20 September 2022

### 2210545

# **Appendix A – Response to Submissions**

Extracts from public authority submissions and submissions from organisations, including stakeholder and interest groups, received in relation to SSD-32927319 and a response to each of these matters has been provided in the sections below.

HS 09: Harris Street Elevation facing East

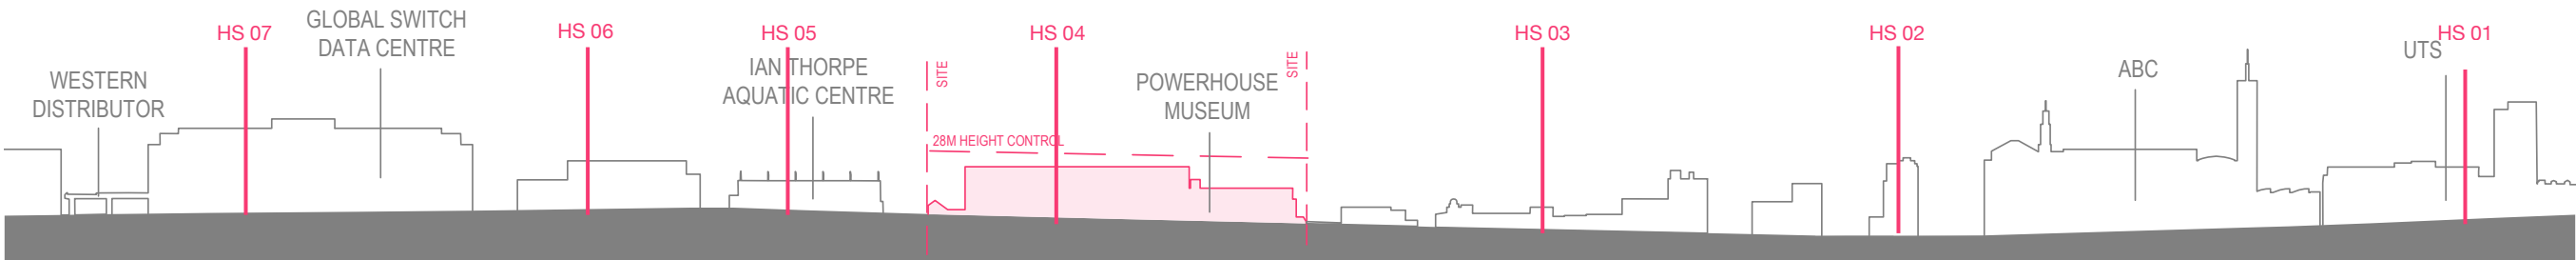
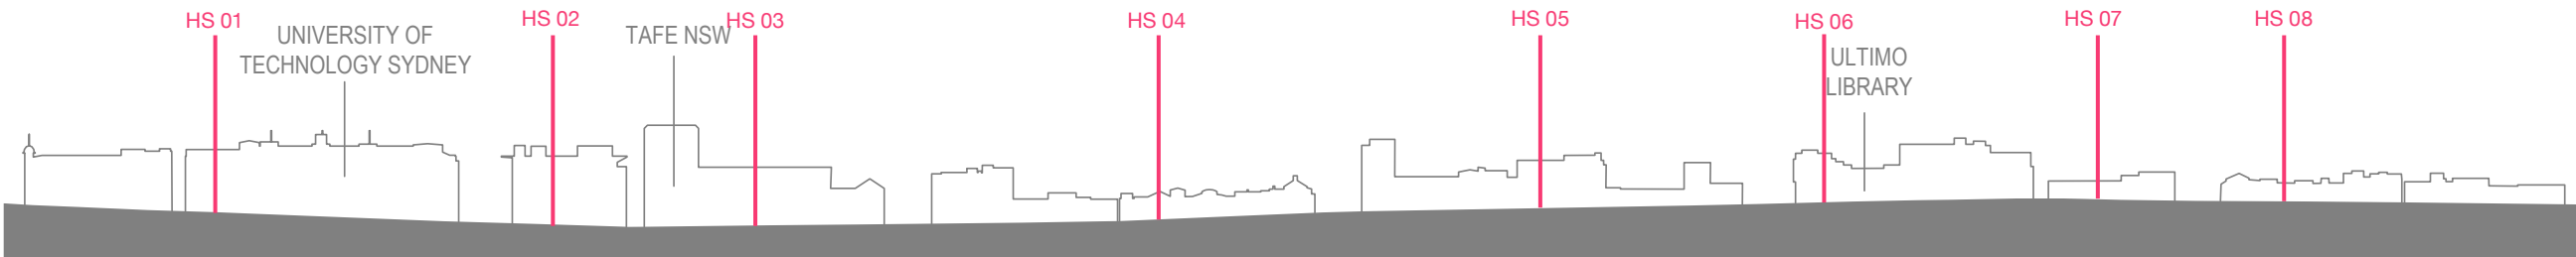
- The street elevations around the site should include the opposite sides of the streets around the site. Refer Section 3.10 Pg 40, 41 Part 3 of the UDR.

A figure ground drawing has been developed and is included in the updated urban design analysis. The drawing clearly demonstrates the disparate development patterns surrounding the Powerhouse site. This is supported by further elevational analysis that clearly demonstrates a varying street wall heights and development patterns throughout the area. Further the sectional analysis outlines how the topography of the area has influenced development patterns.
